HyNet Carbon Dioxide Pipeline

Written Response Statement on behalf of Peel
NRE

Planning Inspectorate Reference: EN070007

4 July 2023 (Deadline 5)

DRAWING TITLE  
**Ince - Above Ground Installation (AGI) Drainage Layout**

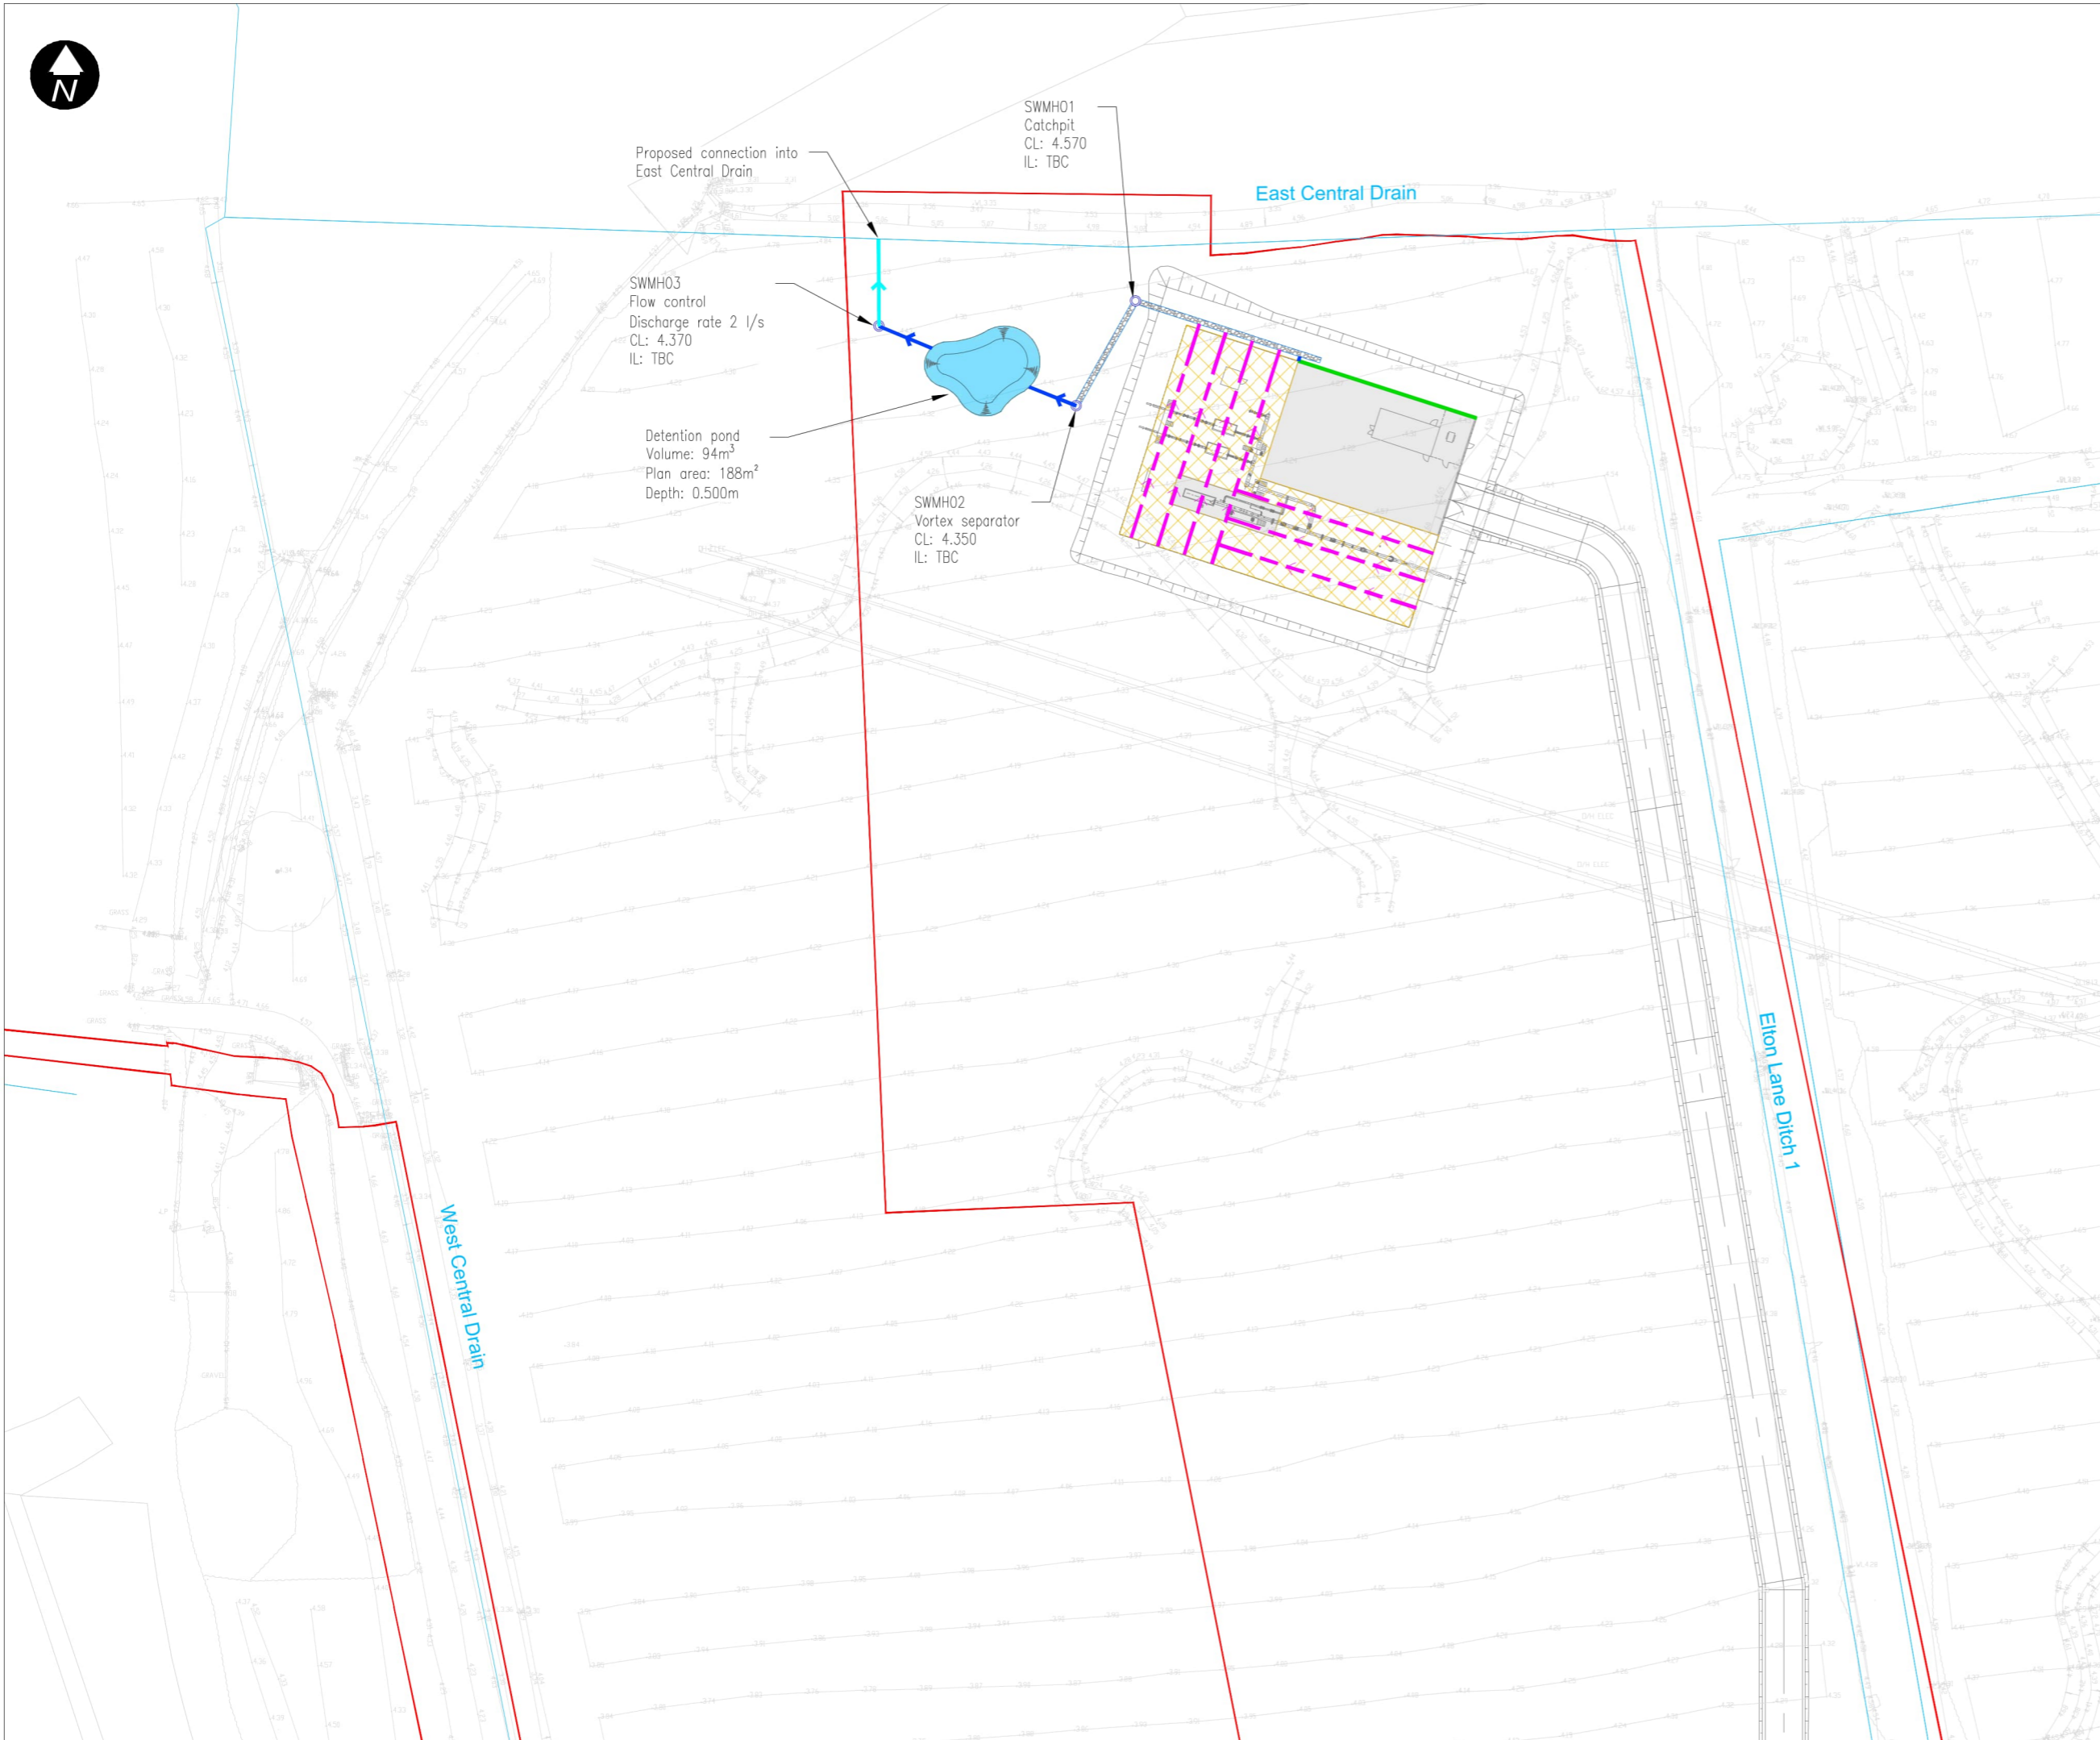
- 2.4 The Ince AGI Landscape Layout (ref. D.2.14-LAY-Sheet 2 Rev B) identifies the location for landscaping/ecological mitigation and a drainage detention pond. The current location of such features has the possibility to constrain future planned development across the Affected Land. Peel NRE accordingly objects to the current proposed layout of the Ince AGI.

- 2.5 Through conversations between Peel NRE and the Applicant, it is understood the layout of the Ince AGI will be updated to addresses Peel NRE's concerns. This is a welcomed proposal. However, until the updated layout plan is formally submitted, and the Applicant obliged to carry out its proposal in accordance with any amended agreed layout, Peel NRE maintains its objection on this basis, although Peel NRE is confident this objection will be resolved with the Applicant.

- full access rights, during both the construction and operation phases, are retained to the Affected Land for the benefit of Peel NRE.
- reconsideration of the location of drainage infrastructure to avoid conflicting with planned development at Protos.

Figure 6.1 – Extract of the Ince Park Plastics Masterplan - Drawing Number: 20039-FRA-XX-00-DR-A-90-0005 P2 approved under application no. 21/04076/FUL and works no.3, EN070007-D.2.4-WP-Sheet 1 [AS-012].

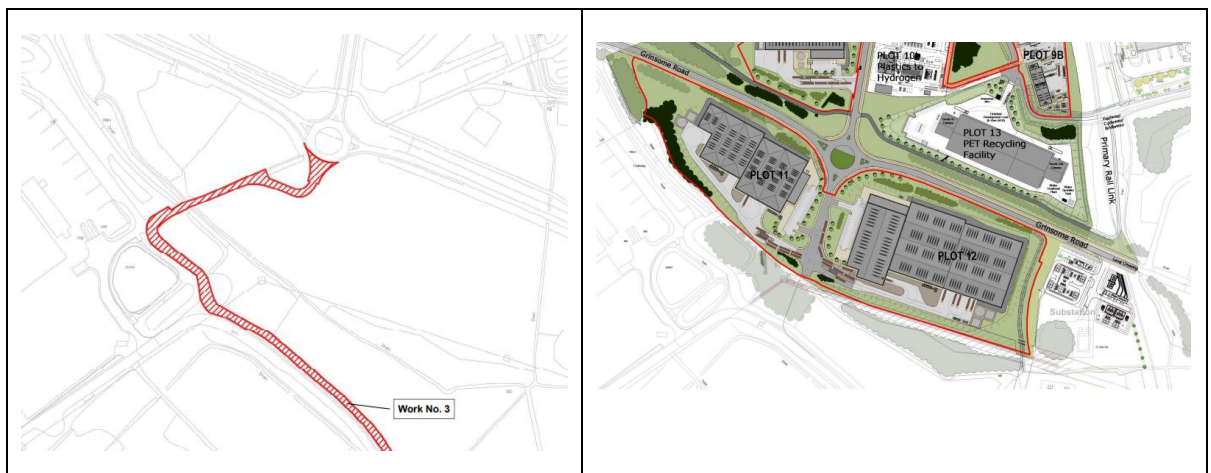
- 2.6 The proposed access continues to conflict with the delivery of the approved Protos Plastics Park (CWACC Planning application ref. 21/04076/FUL), and the delivery of the railway line consented as part of the overarching planning permission for Protos (ref. 14/02277/S73), which would constrain the delivery of the developments. In the absence of agreement by the Applicant to an alternative access, Peel NRE **objects** to the proposed access (as shown on Works Plan ref. EN070007-D.2.4-WP-Sheet 1).

- 2.7 A plan of the approved Plastics Park masterplan (ref. 20039-FRA-XX-00-DR-A-90-0005 P2) is provided with an overlay of the proposed access route to the Ince AGI and pipeline (shown on plan ref. EN070007-D.2.4-WP-Sheet 1). This is provided at **Figure 1** (and at Appendix 16 to the Written Representations (17 April 2023)). This overlay plan clearly shows the conflict of the Applicant's proposed access with the planned development of the Plastics Park at Protos.

- 2.13 An alternative means of access should be identified by the Applicant to avoid conflicting with planned development at Protos, and avoid conflicting with the strategic ambitions established by CWACC in their adopted Local Plan; or negotiations should continue with Peel NRE as part of the property terms to reach agreement on the access arrangement, as set out in the SoCG.

- 2.15 At this stage Peel NRE **objects in principle** to the proposed means of access. An alternative means of access should be identified by the Applicant to avoid conflicting with planned development at Protos. Peel NRE is in discussions with the Applicant regarding an alternative means of access and the parties are also close to reaching agreement via Protective Provisions within the draft DCO which, if agreed, would go some way towards alleviating Peel NRE's concerns.
